## HISTORIC PRESERVATION BOARD

December 13, 2012

Re: Construction of Handicap Ramp; 13 Carroll

Floor Plan H.C. Ramp Detail

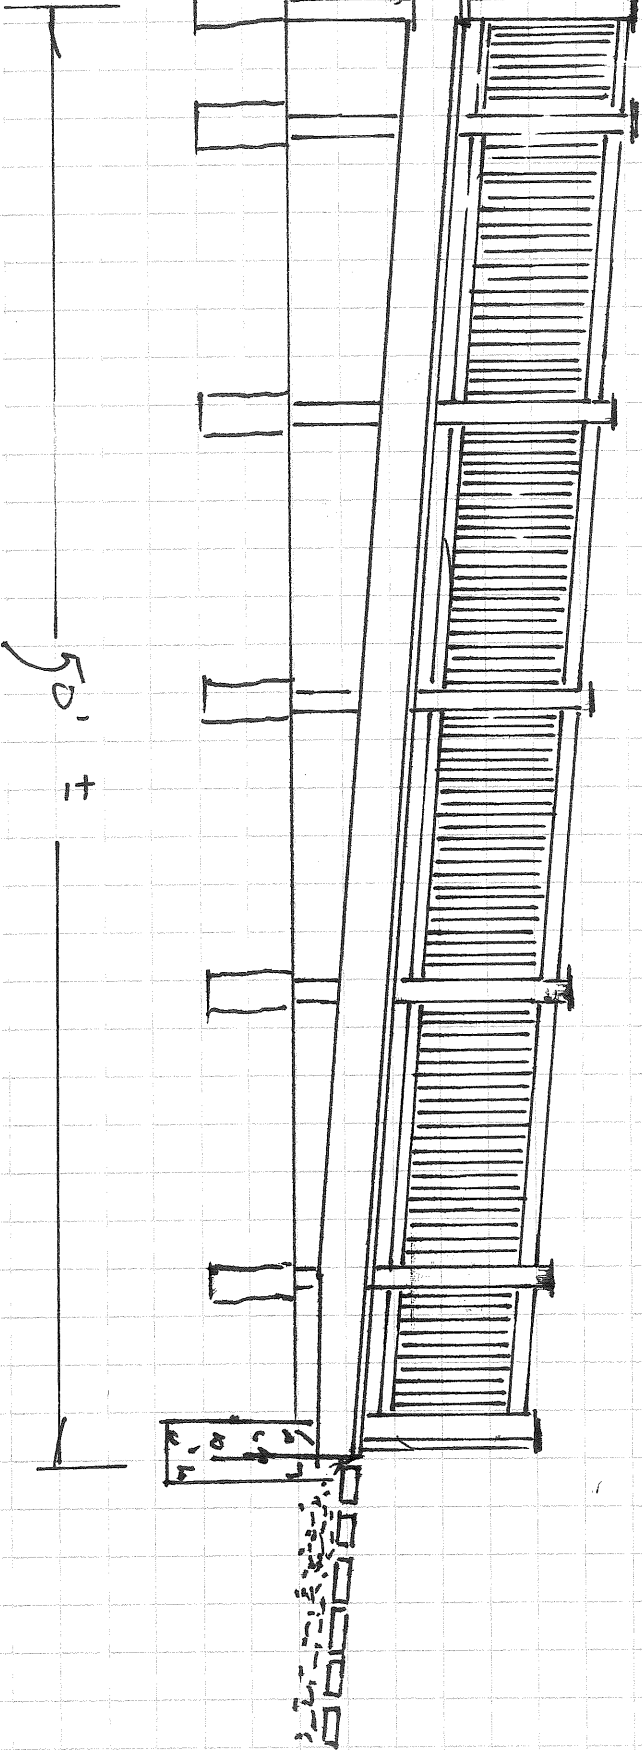
- A timer to be added to the switch that controls the post lights. Time to be limited to that necessary for entering or exiting the building only.
- If an additional (graspable) handrail is required, it should be installed on the inboard side of the ramp.
- When/if the ramp is removed, the wall-mounted security light shall be removed and an alternative specification for a more recessive fixture be submitted for approval by staff.
